ENG-SF18027-2024R1 - CDs.pdf Markup Summary

Subject:
Page Index: 1
Date: 3/26/2024 10:46:08 AM
Author: Jeff Rice - EPC Engineering Review
Color: 
Layer:
Space:
Page Label: [1] Layout1

DESIGNED BY PRA
SCALE (H) 1" = 200'
DATE 2-29-24
DRAWN BY PRA
SCALE (V) 1" = N/A
SHEET 9 OF 14
JOB NO. 1185.31

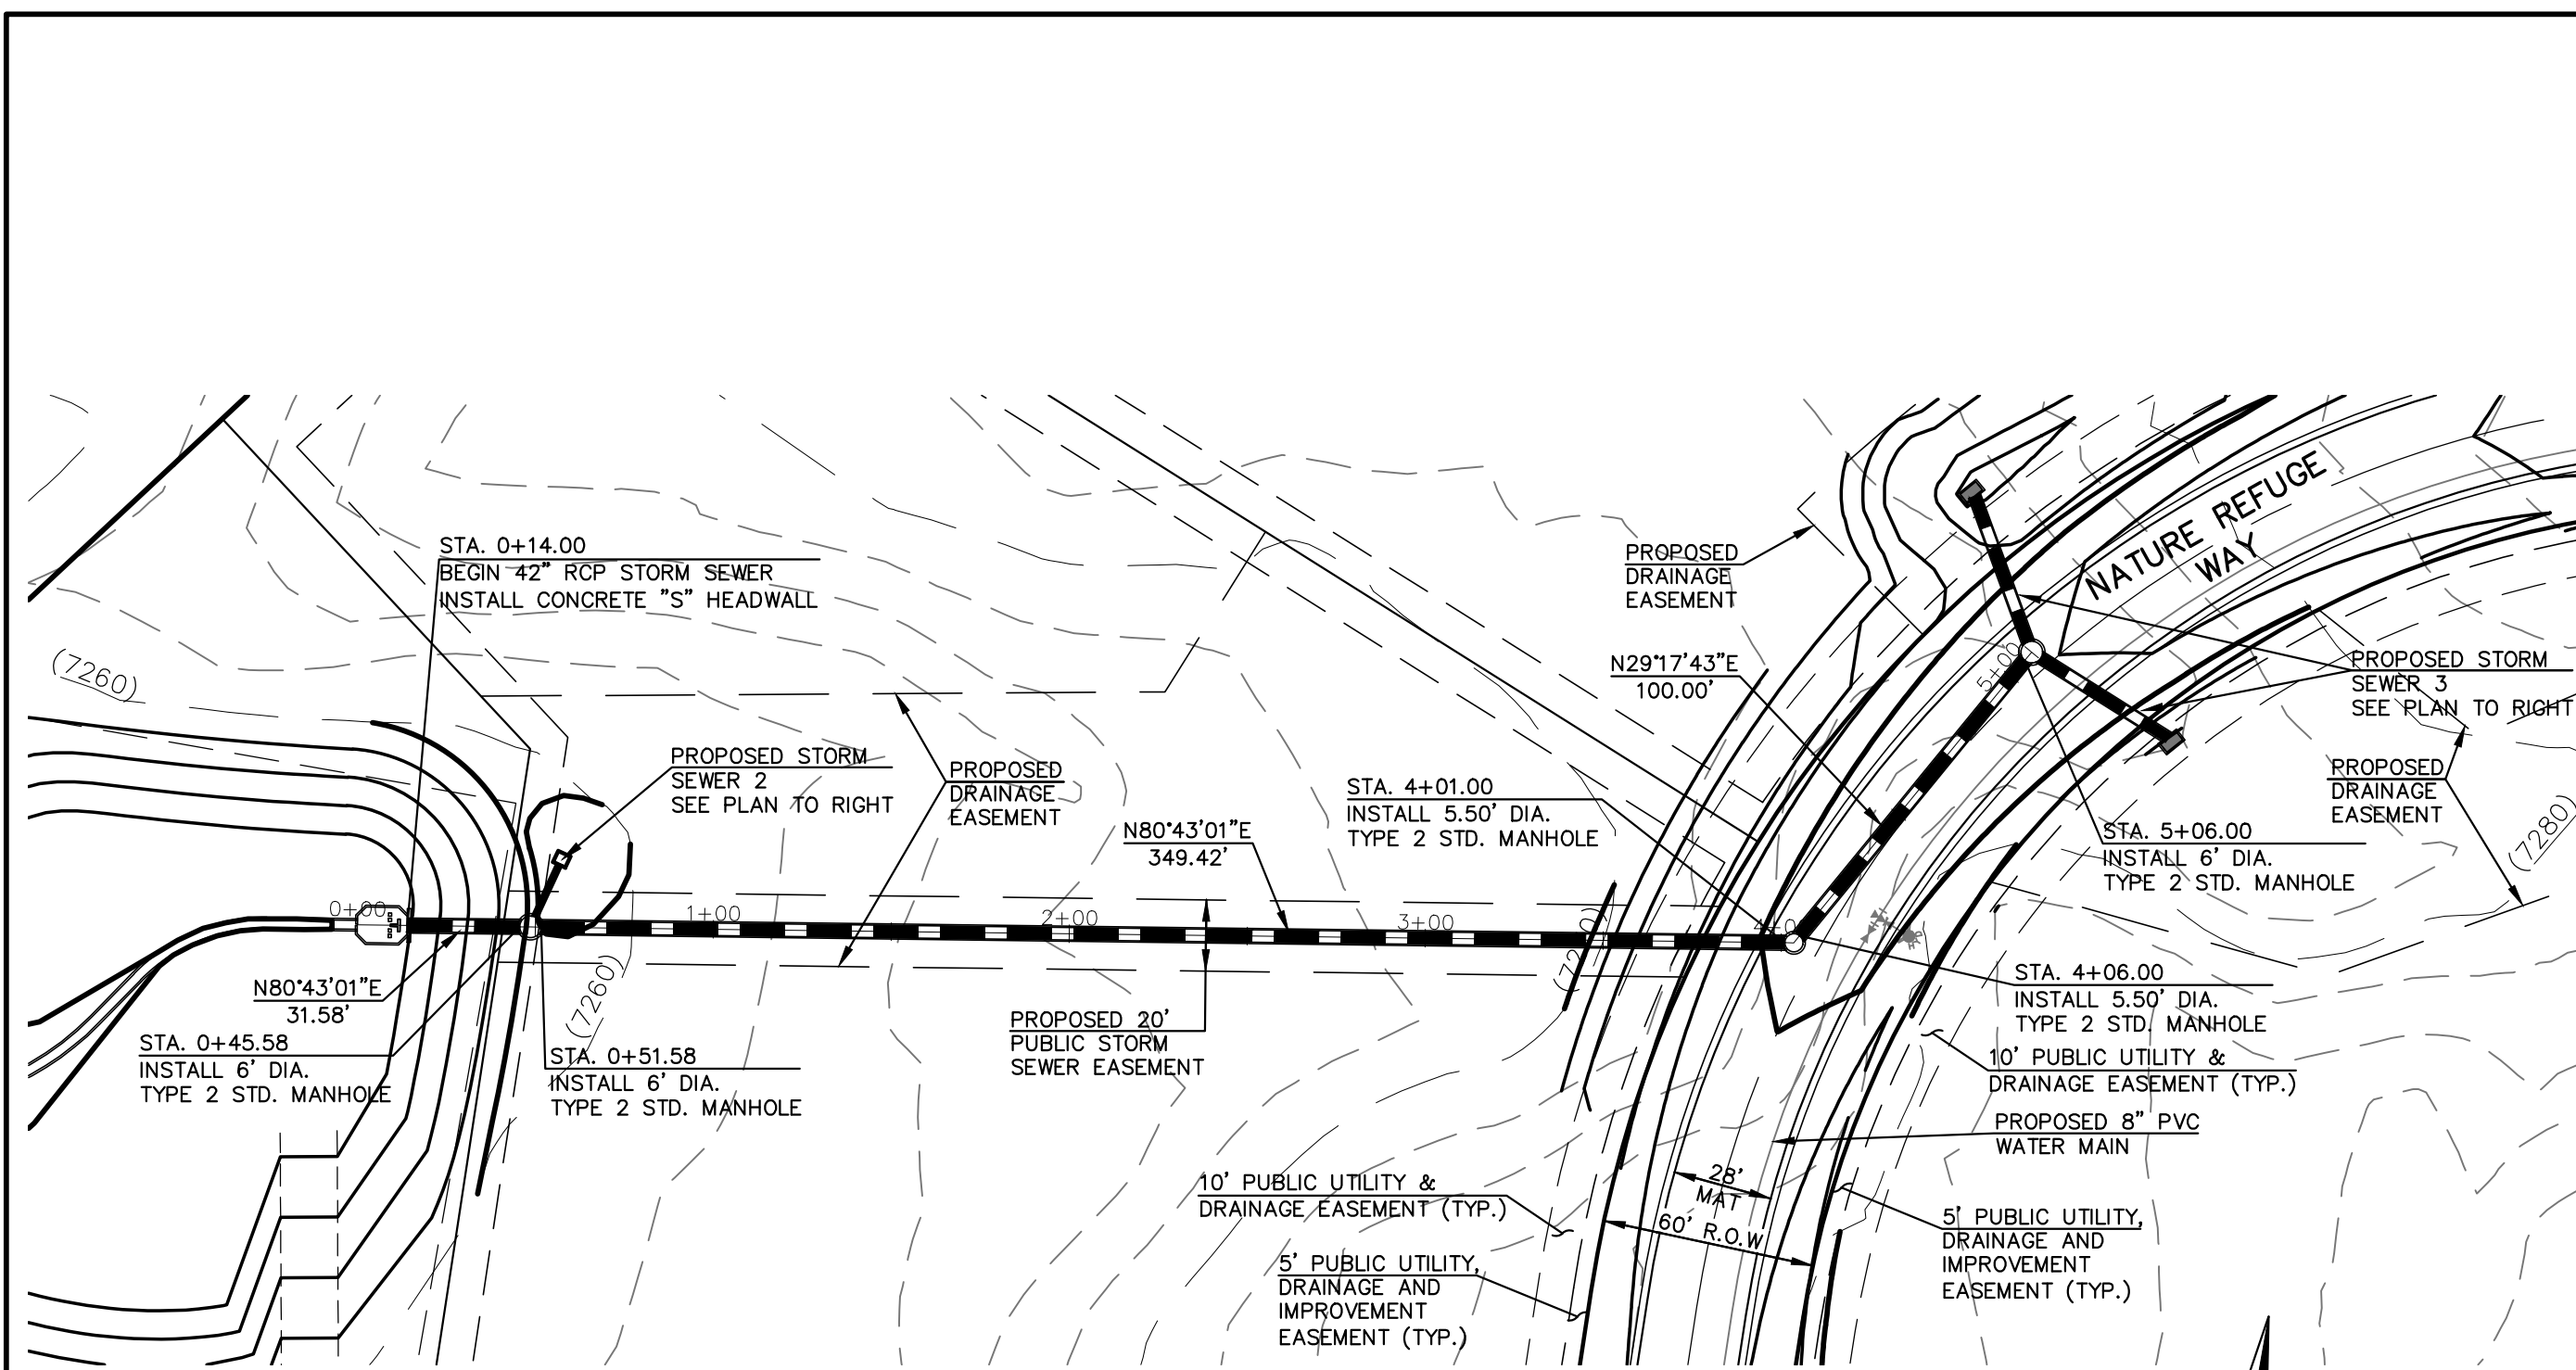
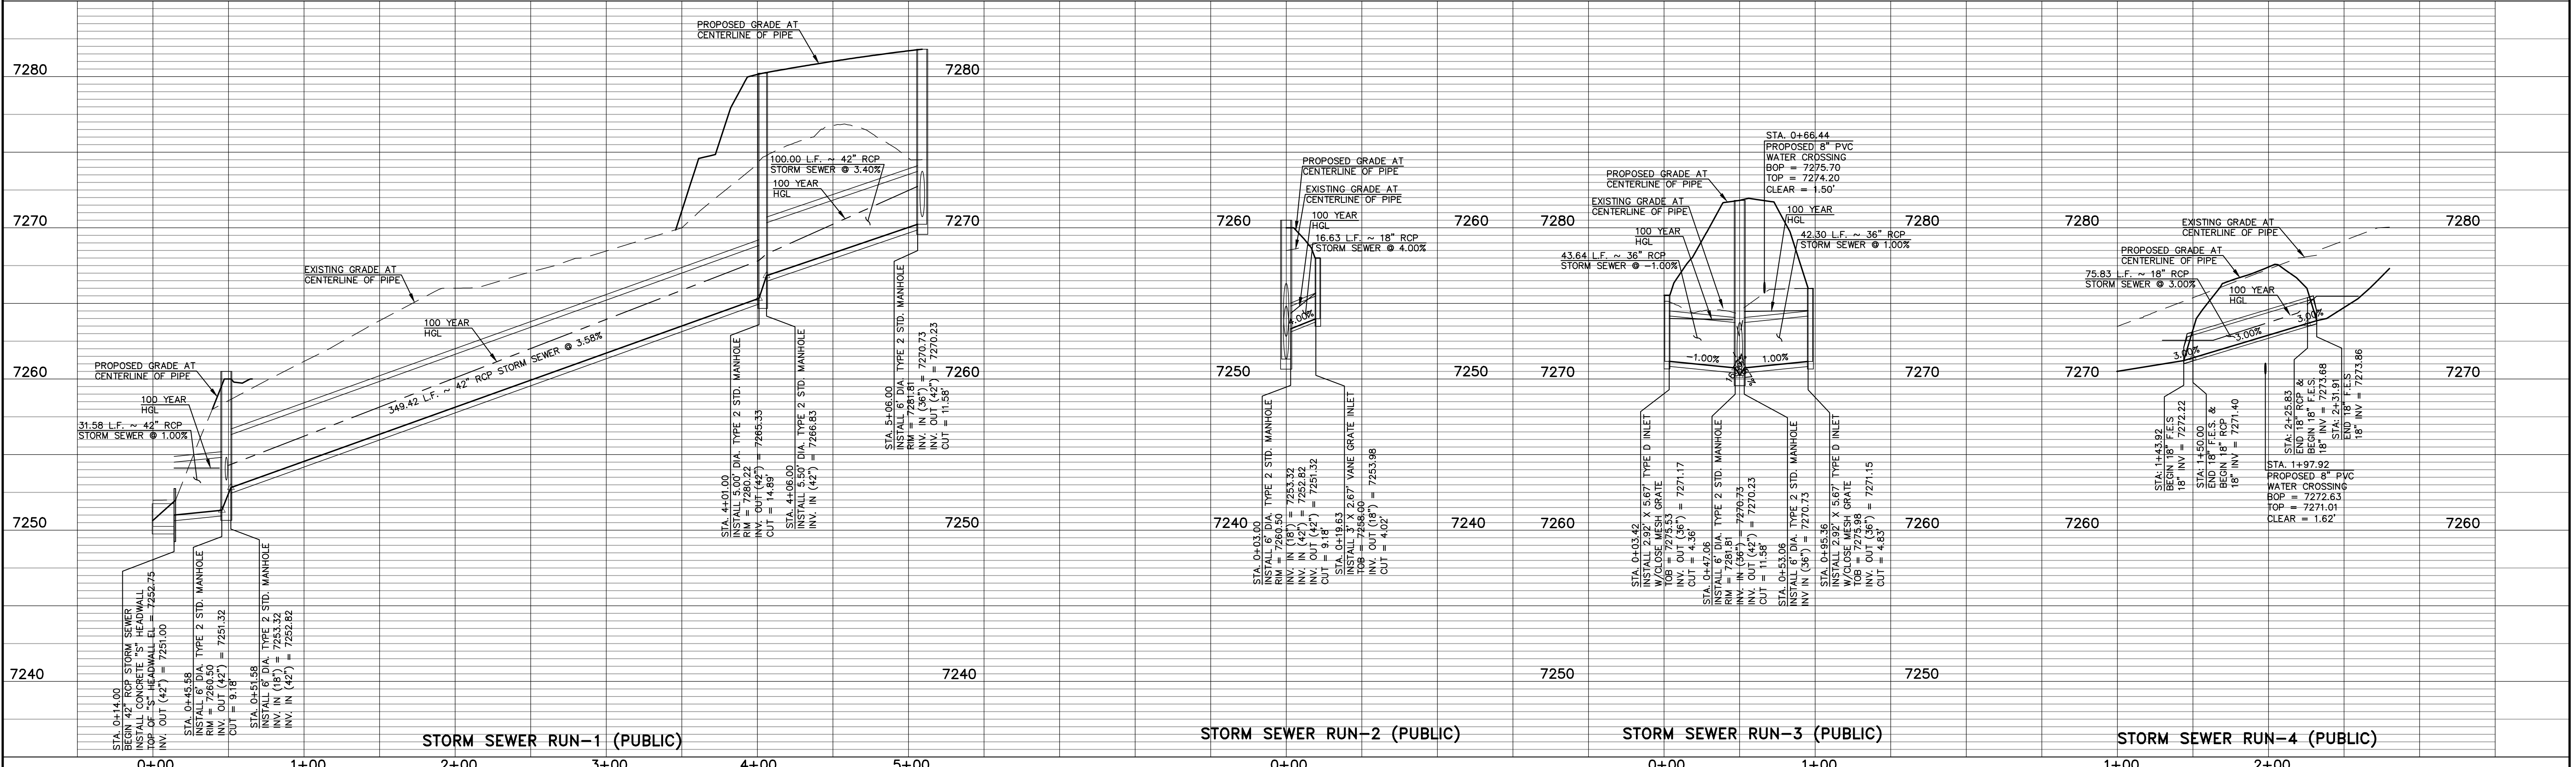
Provide a typical section on where light poles will be placed outside of clear zone and ditch

Provide a typical section on where light poles will be placed outside of clear zone and ditch
